TEXT_ISH4_Session2_A47Blofield_09112021

Hello, it's 355 the hearing is resumed. Can I just check that everybody can see and hear me? Okay. Yes, I can see and hear you. Thank you. So moving on to the next bullet point, which was population human health, which was including the proposed cycletrack footpath provision and effects of footpaths. So I've already addressed some inconsistencies between the DCO the rights and access plans in the master plan. In respect to footpaths, I don't intend to do that again here. But I just have a question. Would the location of the proposed block valve compound would that affects the permissive footpath bridleway which travels through this part of Lynwood community woodland in any way to the applicant?

HE551490-GTY-HGN-000-DR-CH-30012

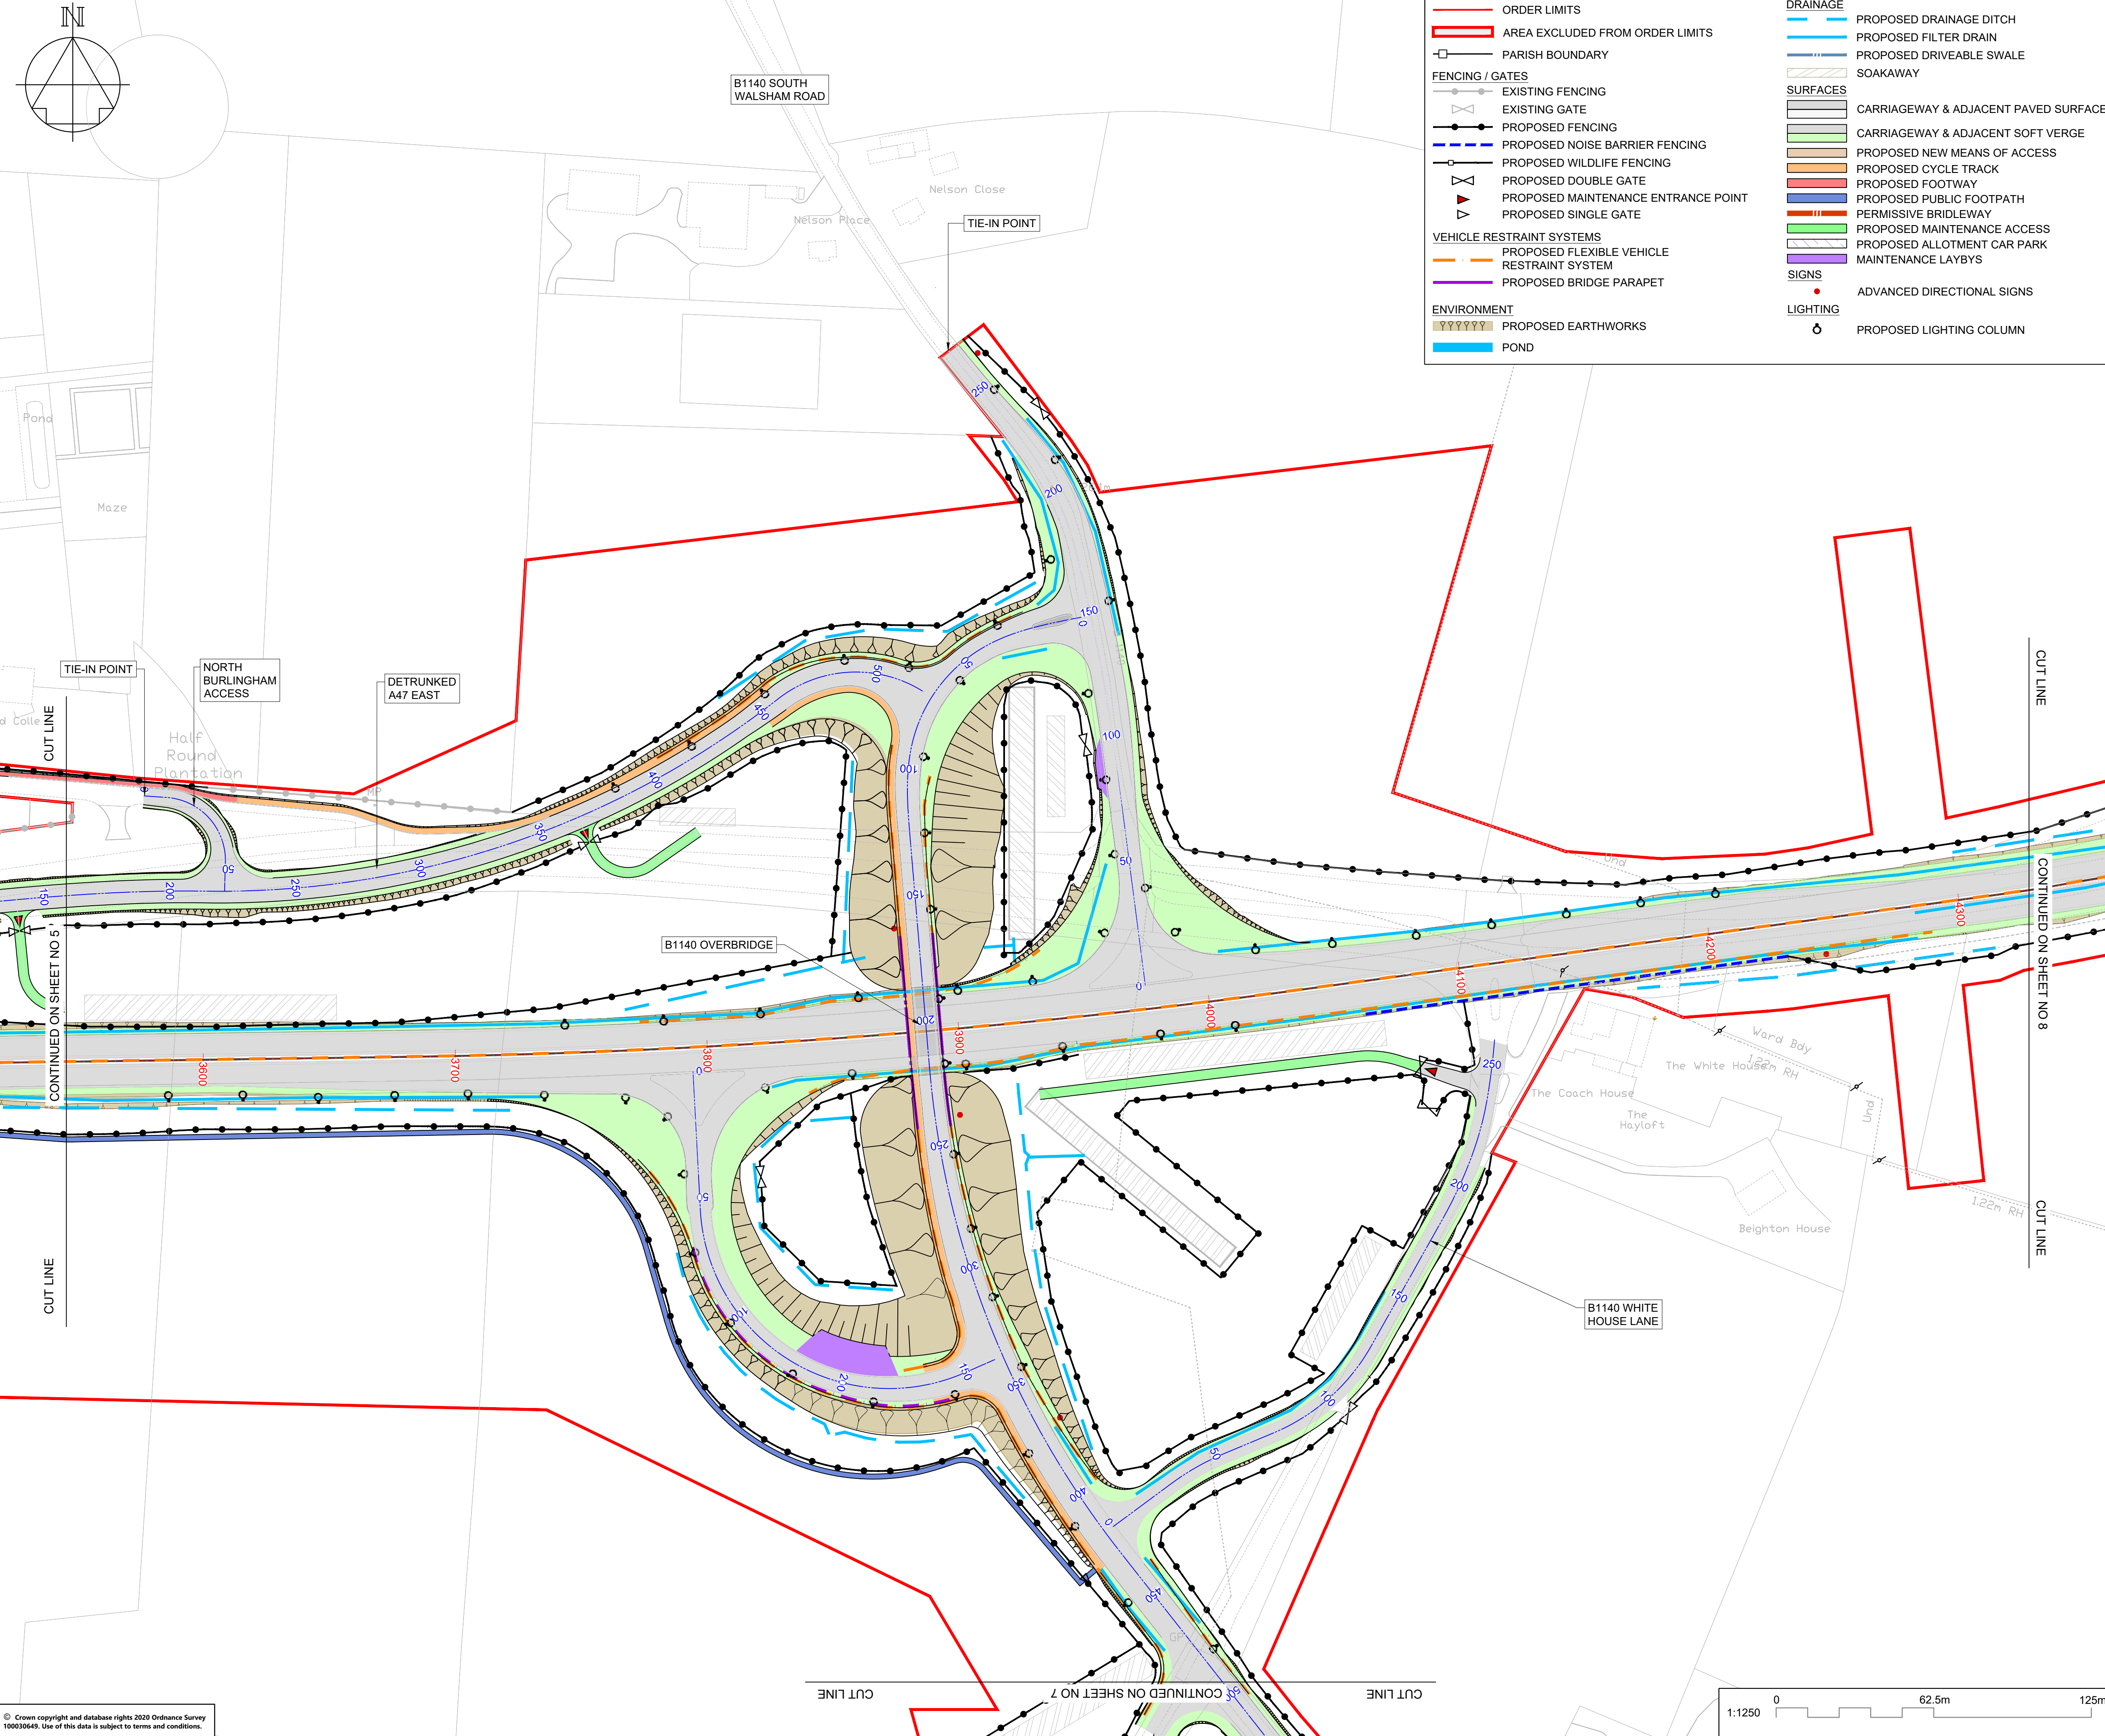
Okay, thank you. Then, could my colleagues bring up sheet two of the plans, please, which is a PDP dash 012?

So sheets, overhead row plans doesn't show the red line boundary or order limits. So can this be added? And can it be confirmed whether there are any any implications for Hydros? In doing so?

So once the red light boundary is added, are there any implications of any headrow has been missed off here, apparently, which may be affected by not identifying the red line boundary.

point. Right. Okay. Come out and be updated for the next deadline, please. Thank you. Moving on, then. So the landscape proposals include the translocation of some important hedgerows. This is shown on the master plan. And mentioned in b two of the Riak. I'm just wondering where where is translocation of hedgerows, which is likely to be a sensitive operation? Where's that covered within the outline landscape and ecology management plan? That Appendix B of the environmental management plan.

And this can be added? Yes. So what was the second part of the question?

All the hedgerows are included. And it's indicated whether or not to be impacted? And not not agnostic, not the information would not change if the red line boundary was added to this
